Department of Transportation

Traffic & Safety – Permits Unit

US-24G (E-X) | Peterson Rd
El Paso County

RE: Hillpointe Apartments (PPR2613)

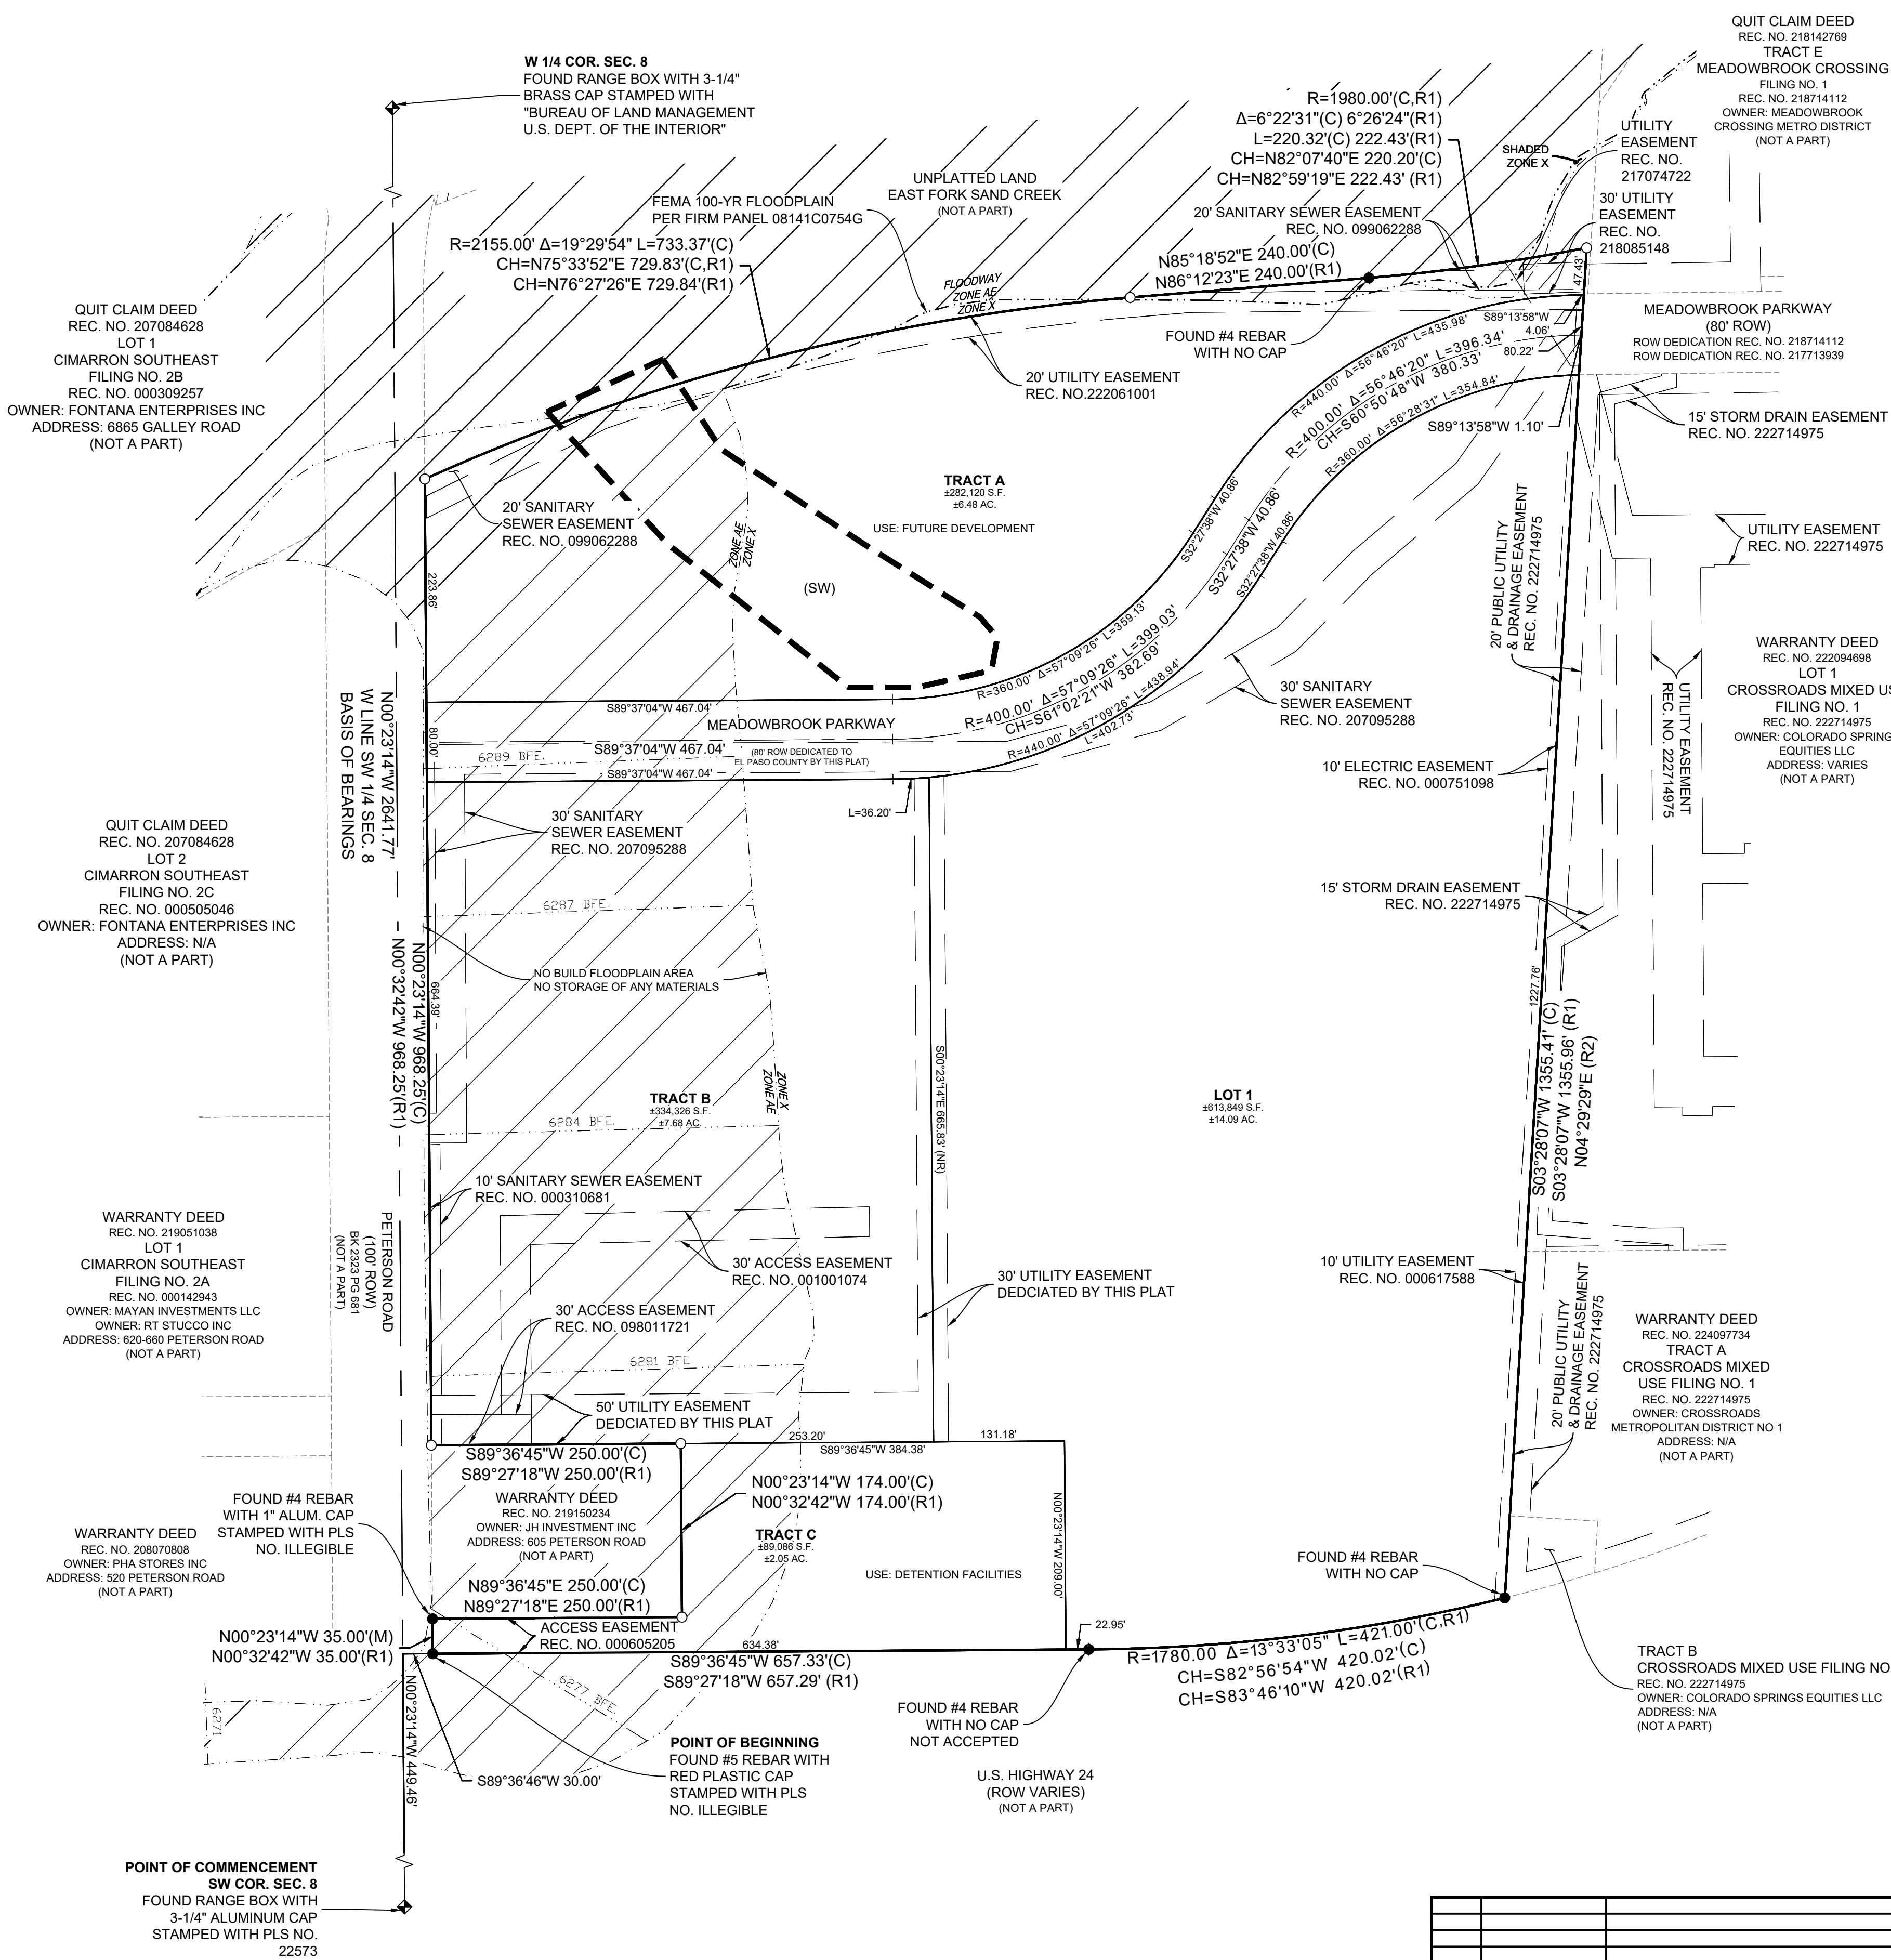
- Roundabouts are being constructed at US-24G (E Platte Avenue) and Peterson Blvd which will improve interchange operations. The existing access is ±275 feet north of the off-ramp terminal from US-24G. The existing cross-over at Panamint Court shall be eliminated and median constructed across.

- A letter from Emergency Services requesting an emergency access at this location and the reason for the request has been received.
- A CDOT Access Permit will be *required* for this development, prior to the subdivision plat being recorded, to document the median opening closure at the existing cross-over at Panamint Court.

- o The median closure to convert the existing access to right-in/right out will be a condition of the permit.
